# Charlotte Department of Transportation

## Memorandum

**Subject:** Rezoning Petition 08-056: Located on the southwest corner of Nations Ford Road and West Tyvola Road  
(revised 6/20/08)

**TYVOLA APARTMENTS**  
**REZONING PETITION NUMBER 2008-056**  
 HATHAWAY DEVELOPMENT  
 TECHNICAL SITE PLAN

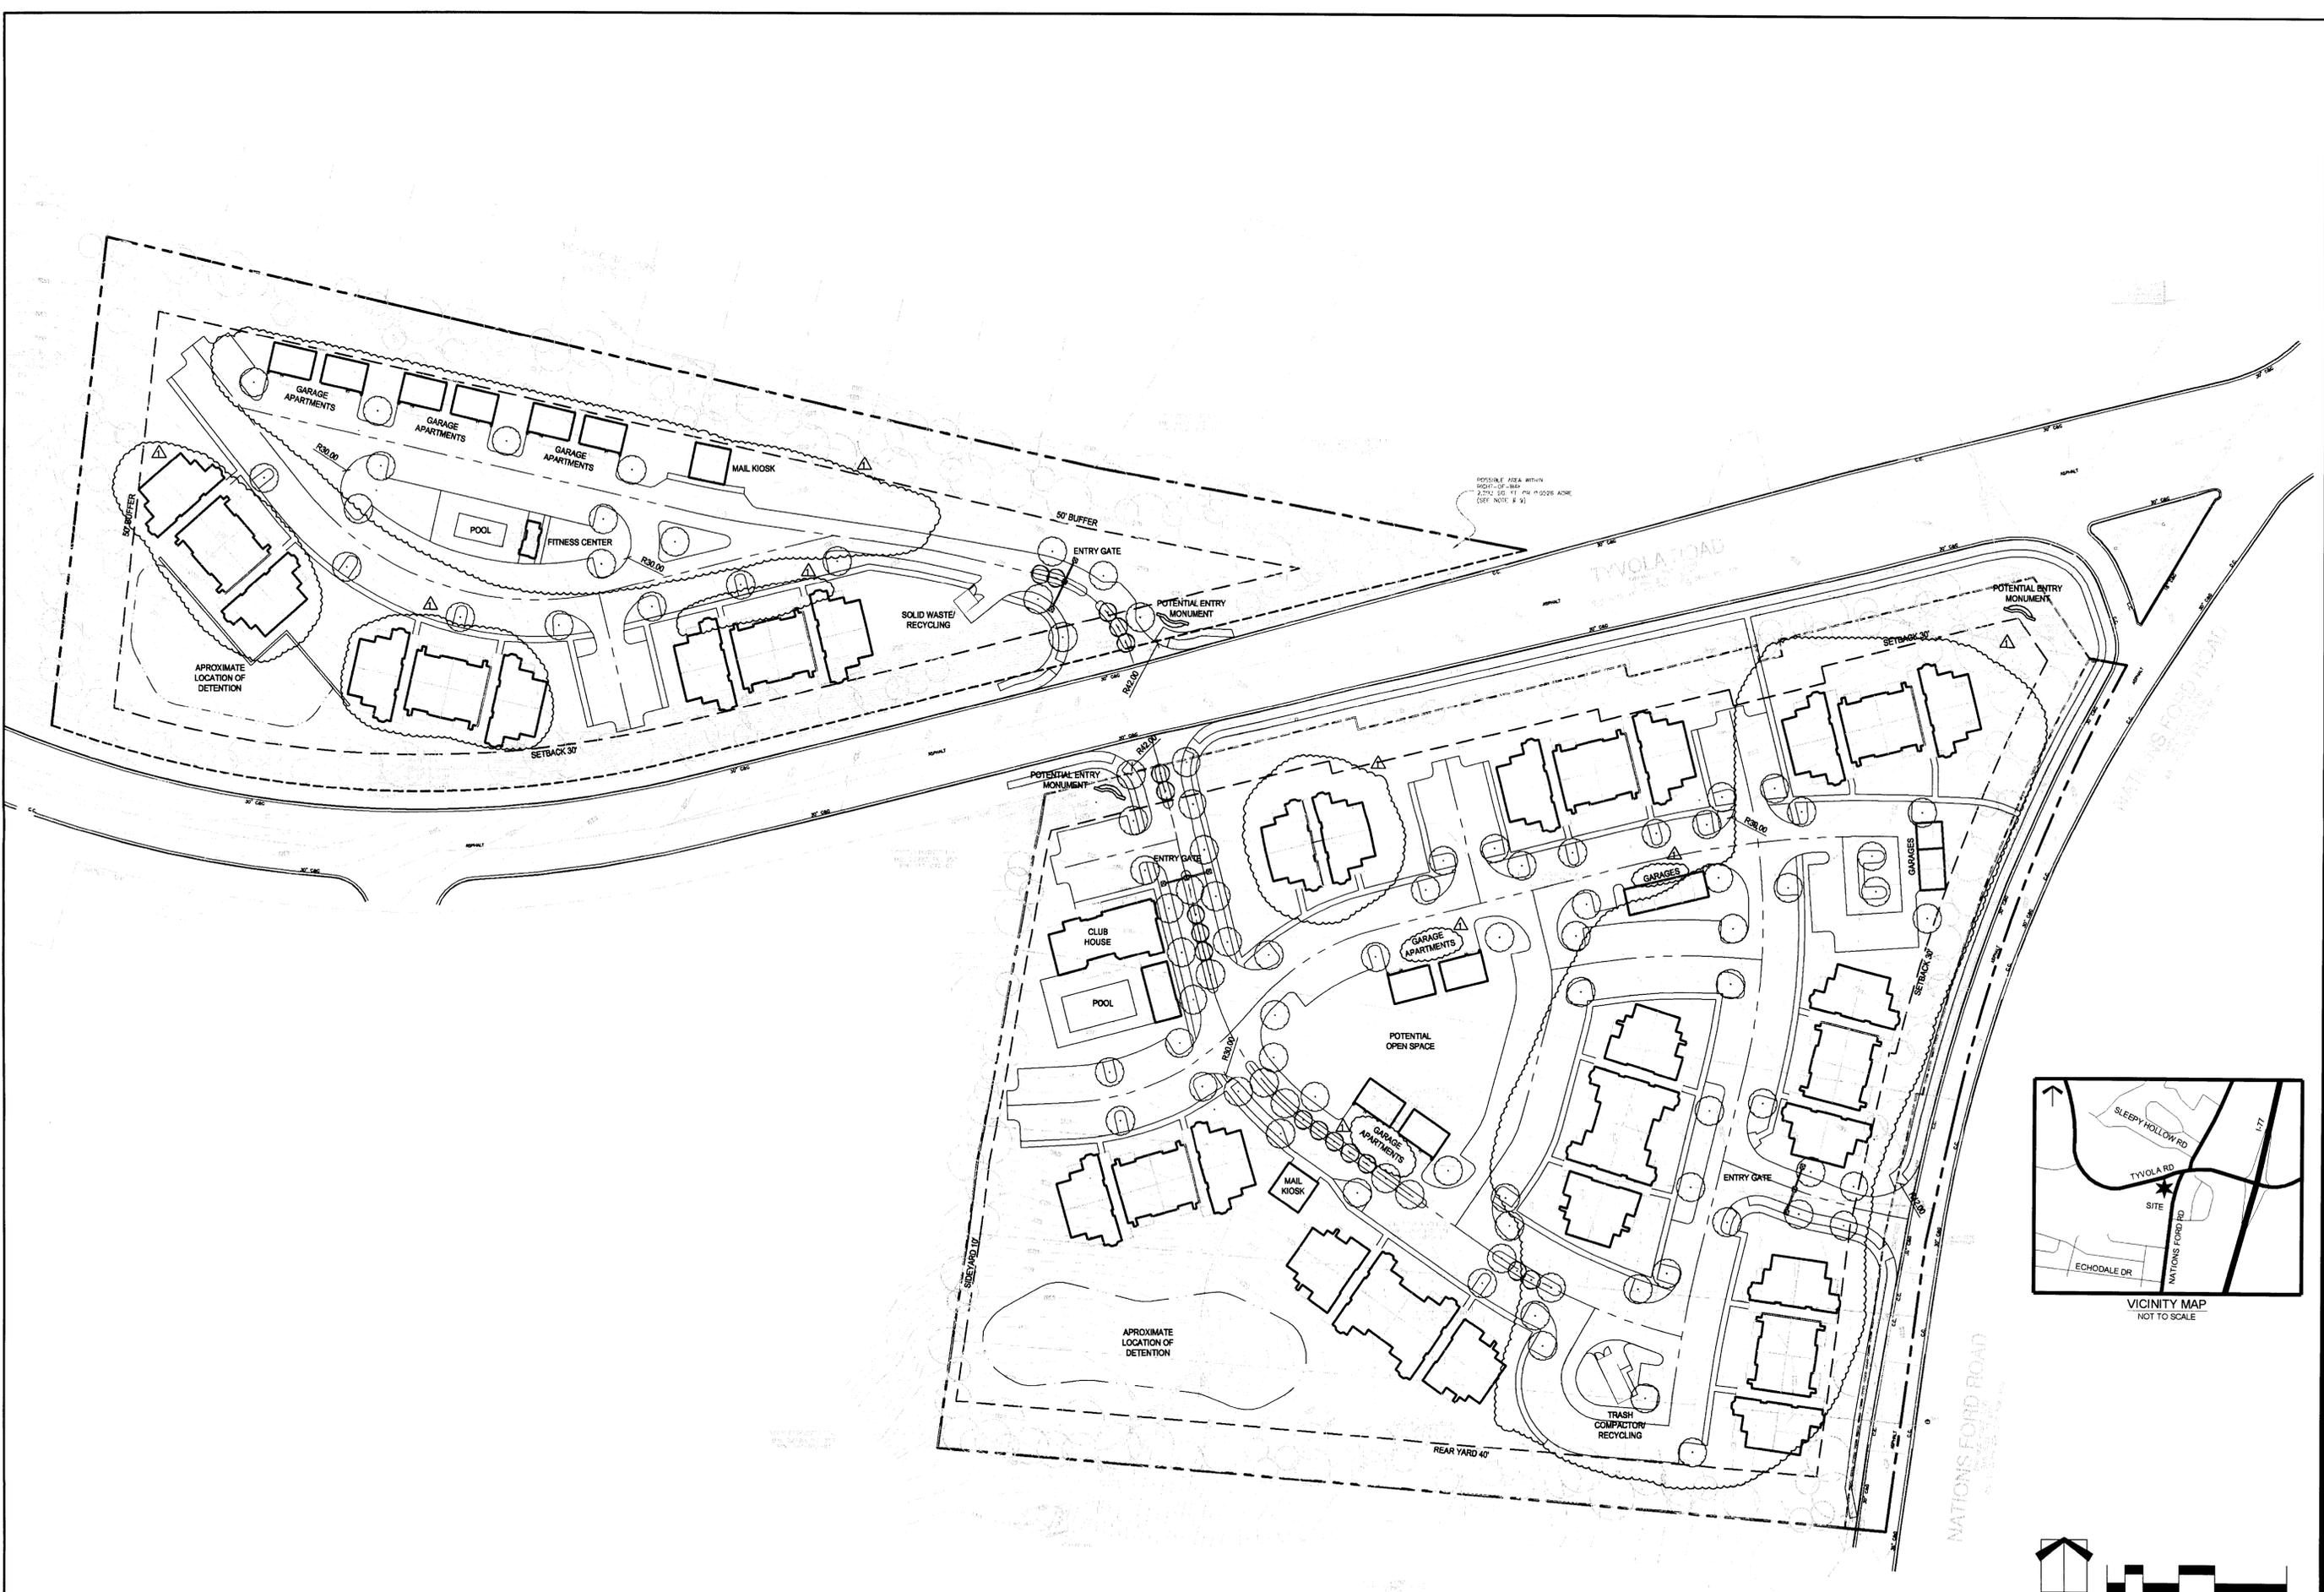
1. Development Note 5 with respect to the Nations Ford Road access appears to indicate that there is some discretion on the part of the petitioner/developer to construct the required left-turn lane. The note needs to be revised for clarification and indicate that "the petitioner/developer will construct the left-turn lane based on the NCDOT design standards and location requirements. If the standards/requirements cannot be met as determined by CDOT/NCDOT, then the driveway will be limited to right-in/right-out movements only and the petitioner/developer will construct a raised concrete median to physically prohibit left-turning movements".
